**REQUEST**

Current Zoning: N1-A (Neighborhood 1-A), RE-3 (Research-3)  
Proposed Zoning: N2-A(CD) (Neighborhood 2-A, Conditional)

The petition proposes to develop a residential community of up to 85 multi-family attached (townhomes) dwelling units on vacant land.

RZ.01

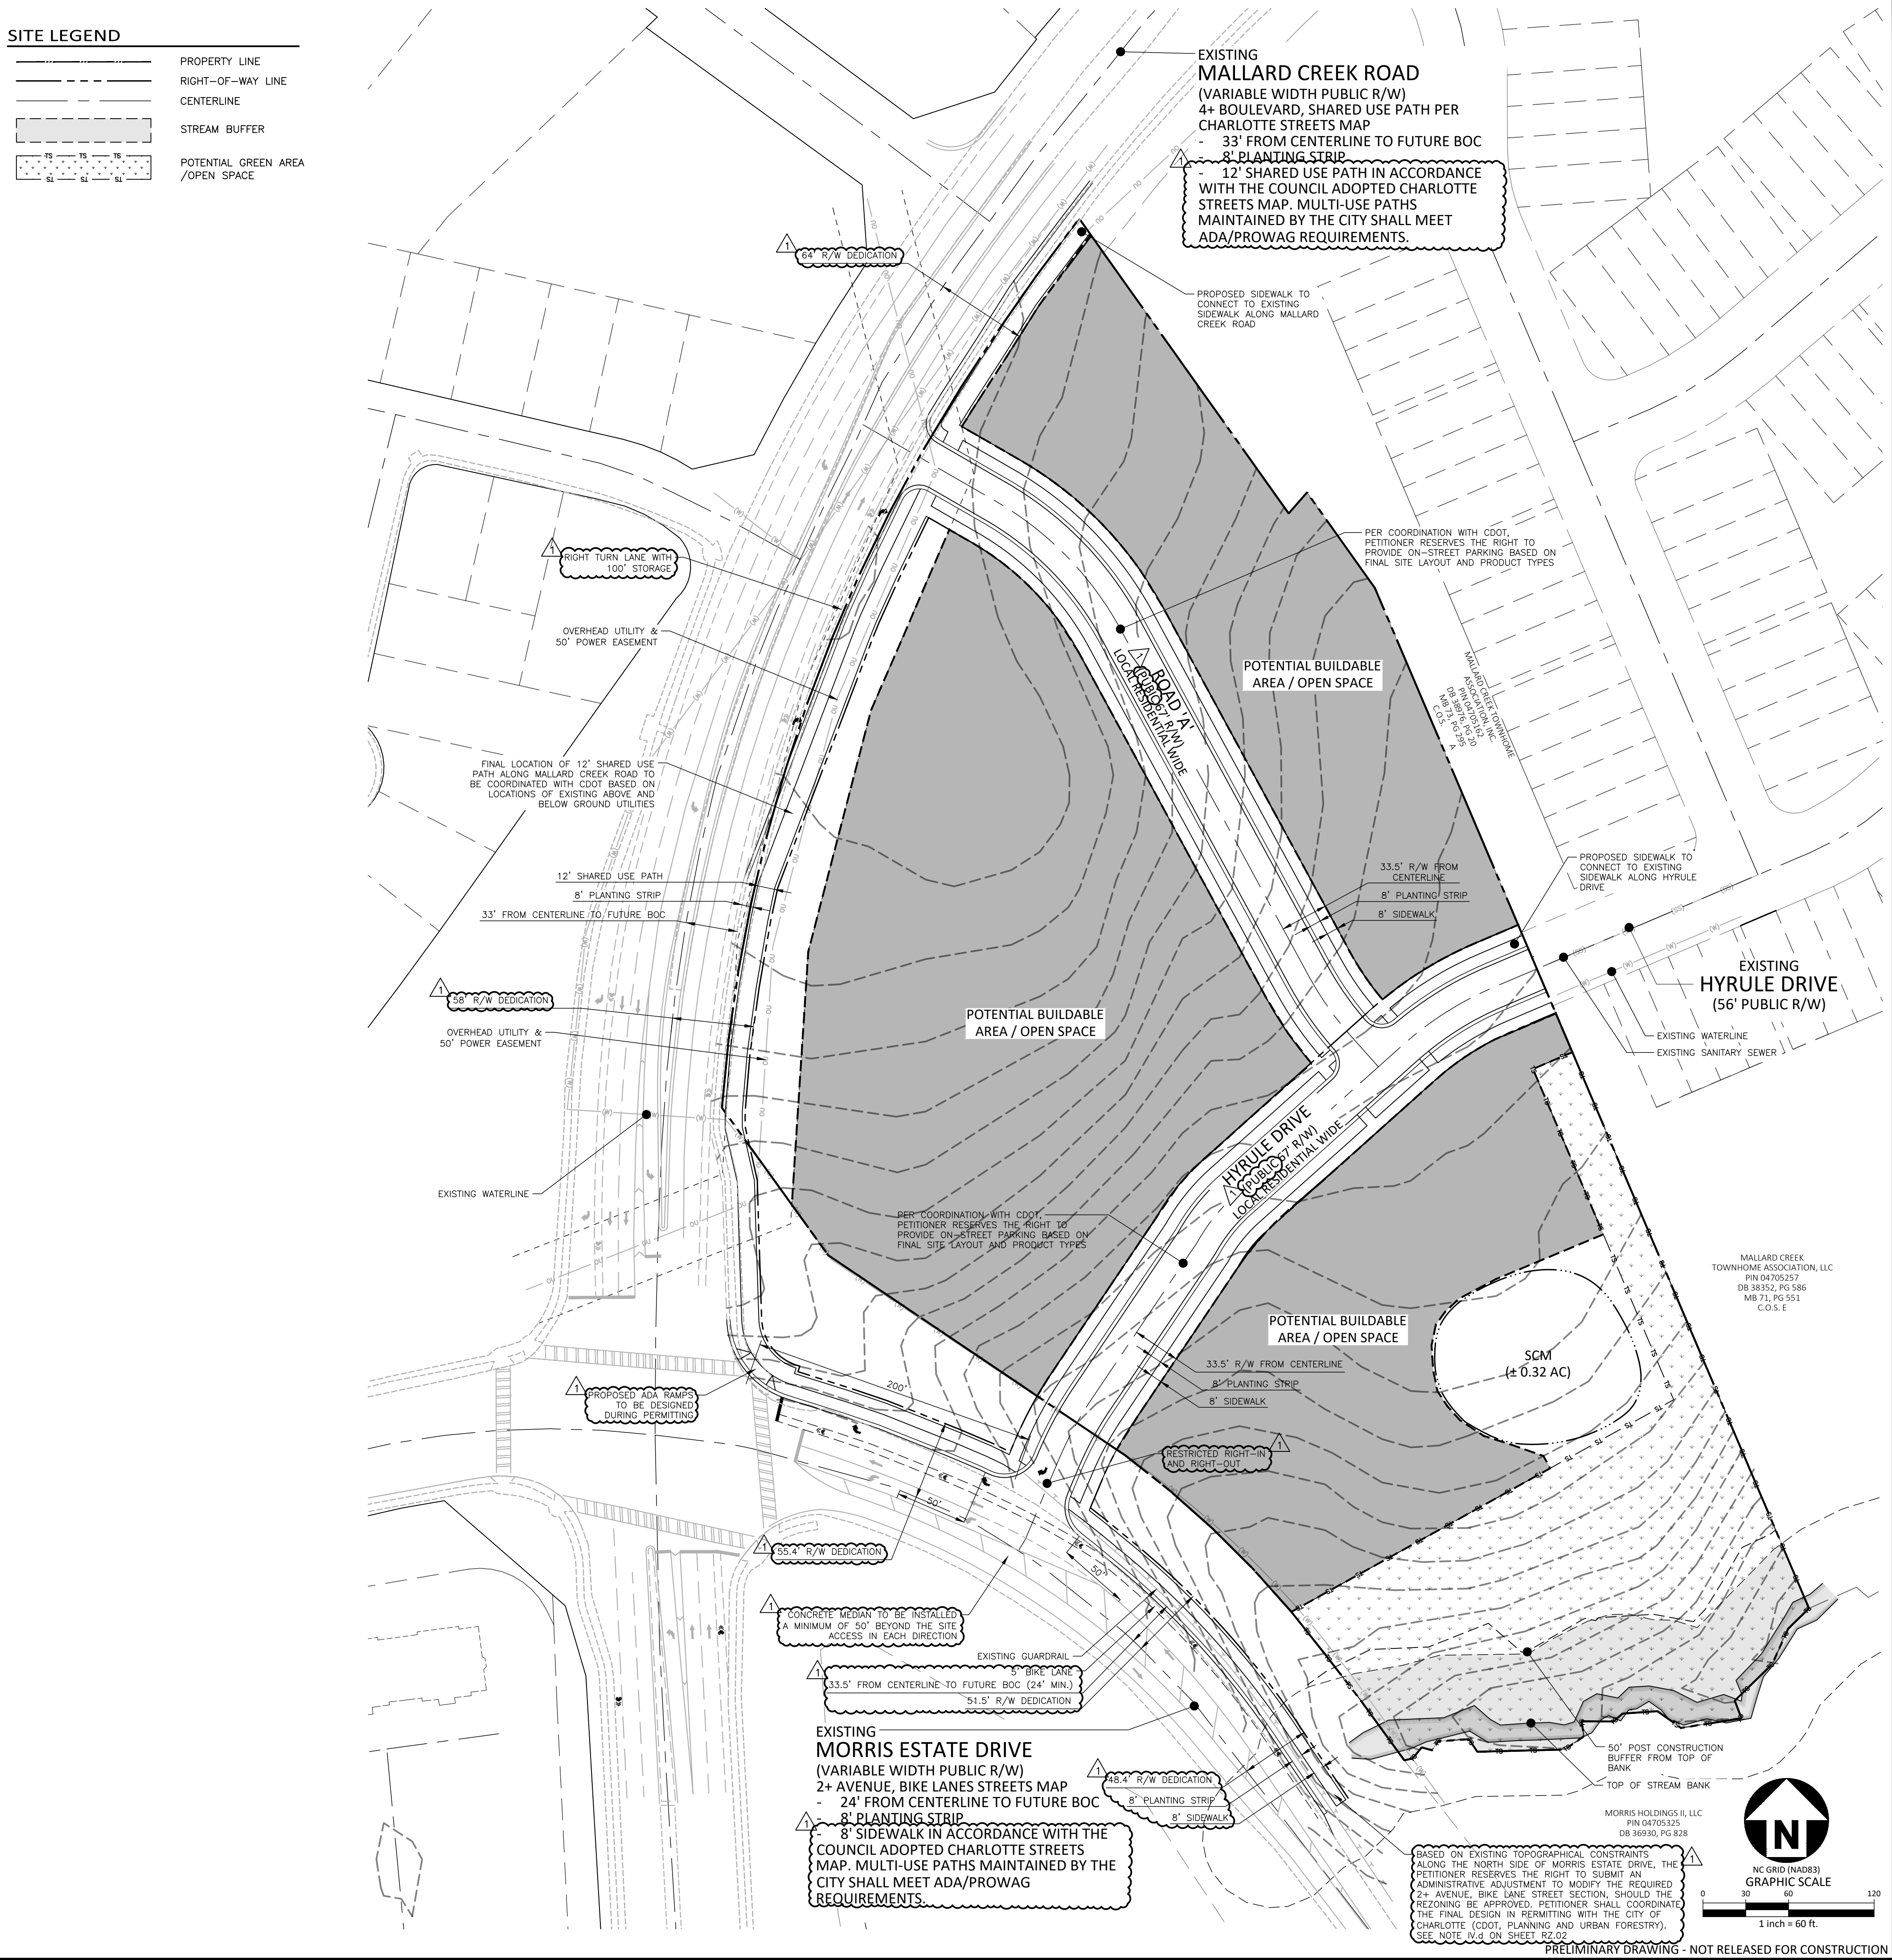
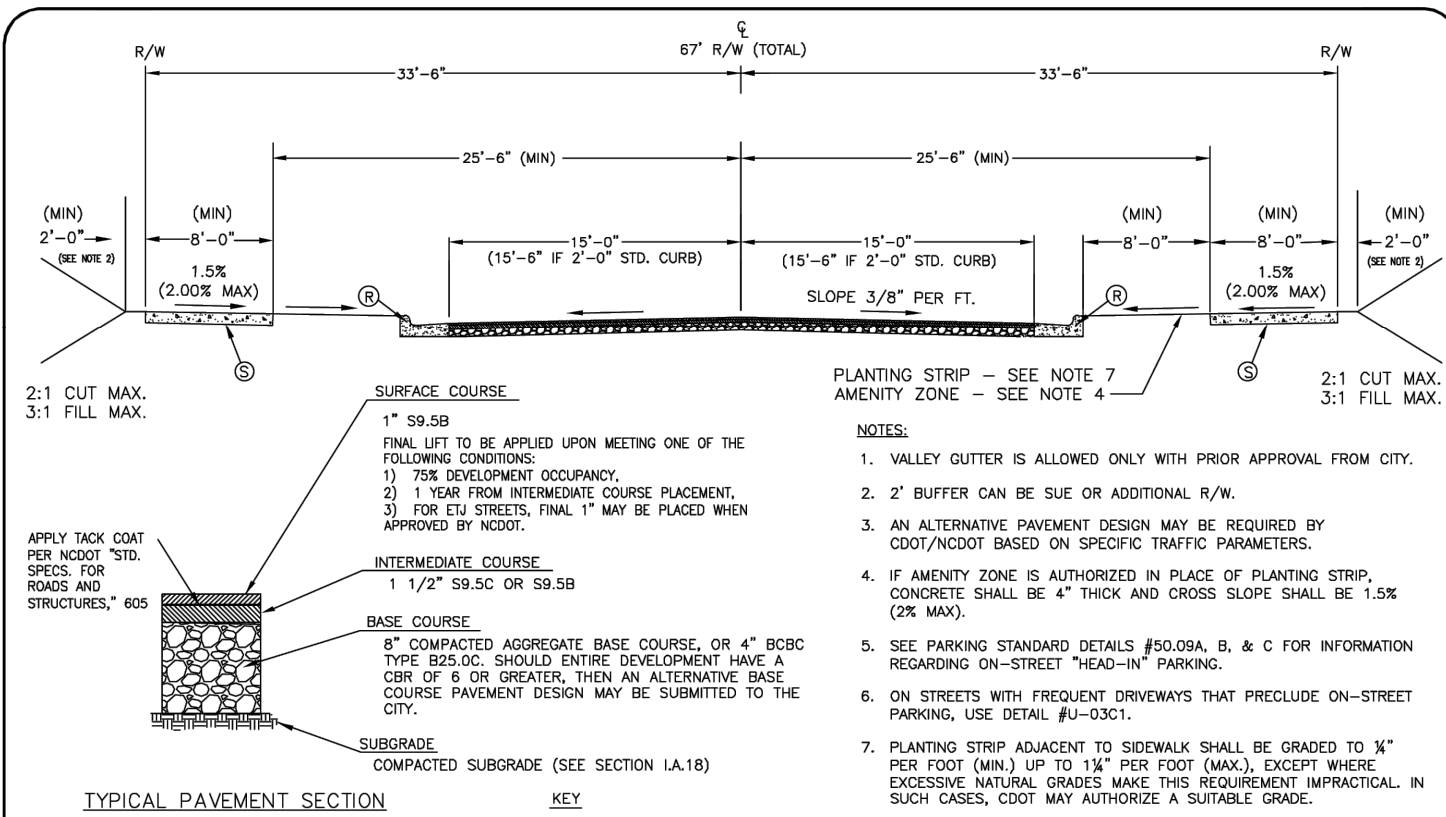
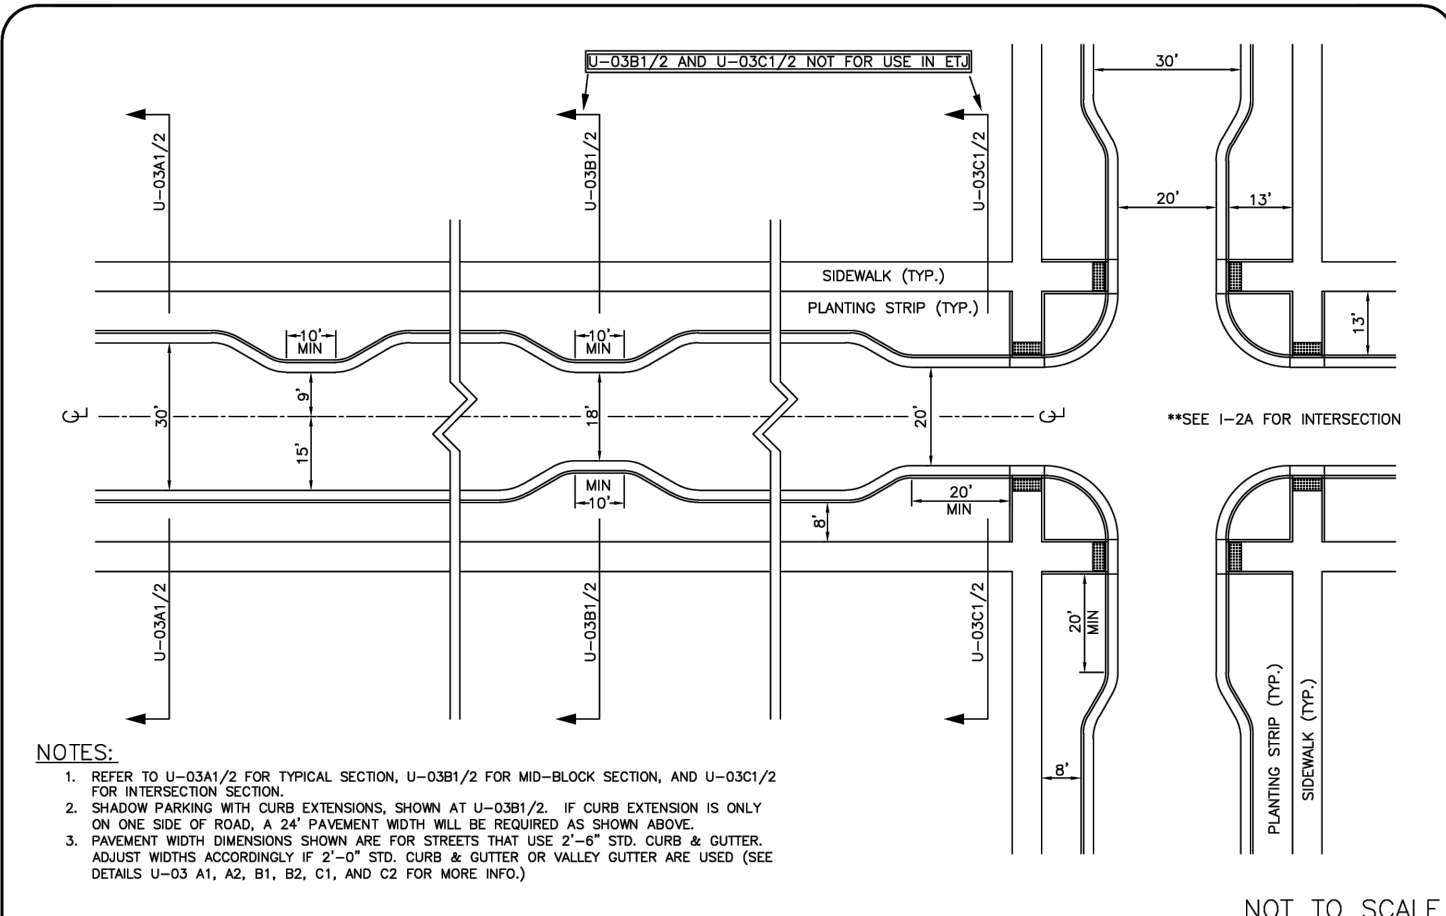
1. Include the following language and description for public art:  
Public art, either in the form of murals, sculpture, or other mediums alongside the details of the art intervention (inclusive of type, size, and location) shall be provided.
2. For each open space component utilized with no prescriptive standard (interactive element, decorative element, shading elements) provide a note to include additional detail during the land development process: When this element is utilized, the petitioner shall provide the details/technical notes on the element along with the location of installation.
3. Provide more detail on site plan: (location of open space, building footprints or bubble diagram). Also note if building will be rear or front loaded.

4. Provide a minimum stoop depth.
